Ref: Planning Objection - 21/03522/OUT
Date: 22nd November 2021

We are writing to make a strong formal objection to the planning application 21/03522/OUT - Land West of Yarnton based primarily on the failure to address increased risk of flooding to the existing community.

Drainage

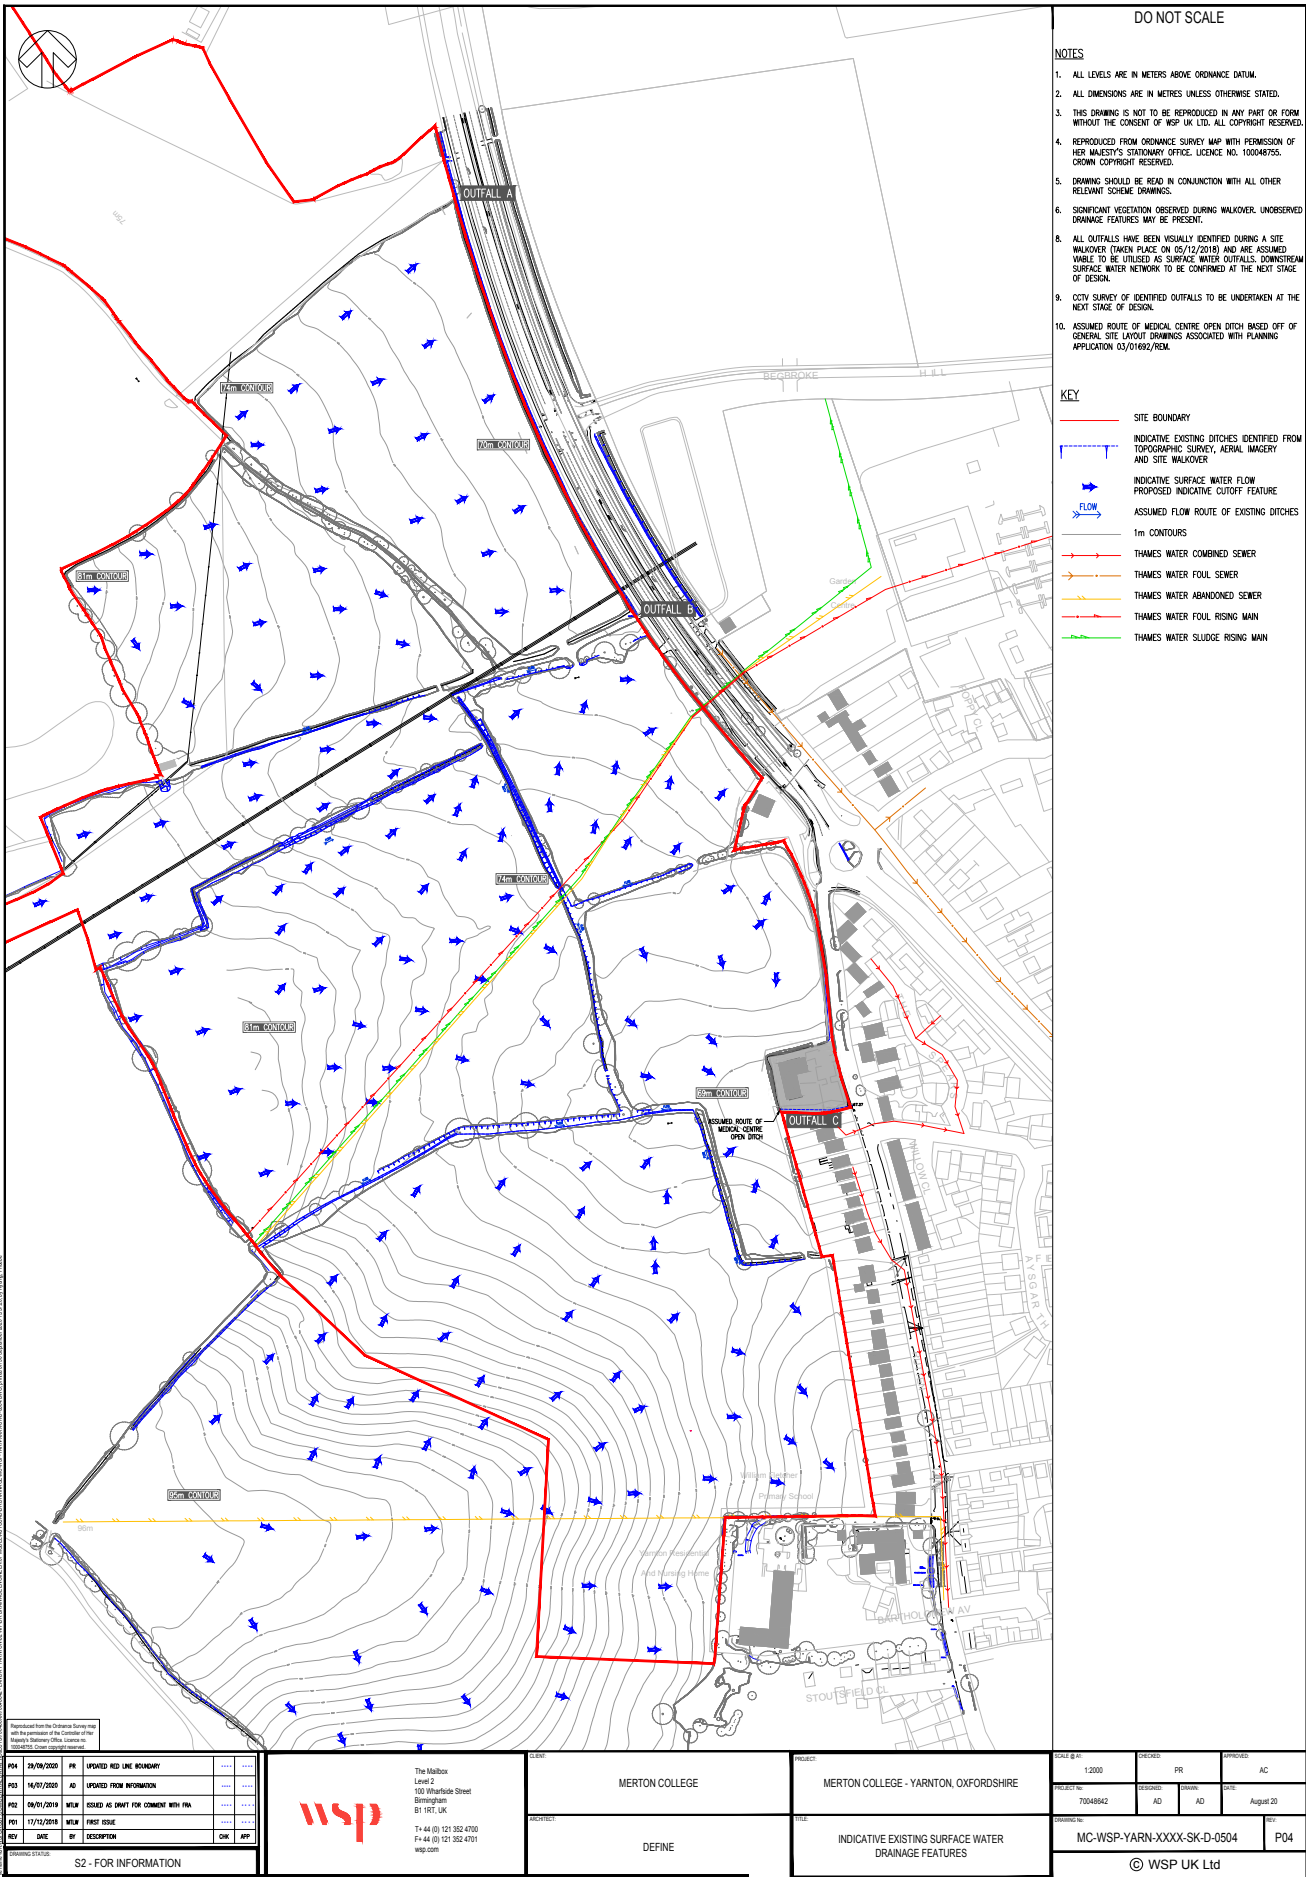
1. There is no acknowledgement or consideration of the combined flood risk at the development site and the existing village – there is a large omission in the flood assessment maps of the known River Thames Flood plain (see comparison maps figure 1 and figure 2 below).

2. There is limited documentation demonstrating an understanding of historic drainage channels and local topography. The proposed development will lead to a heightened flood risk for the Yarnton community due to a squeezing of available drainage capacity between the PR9 development site (the source) and the Thames flood plain, (the sink) on which the village of Yarnton borders highlighted by point 1 above.
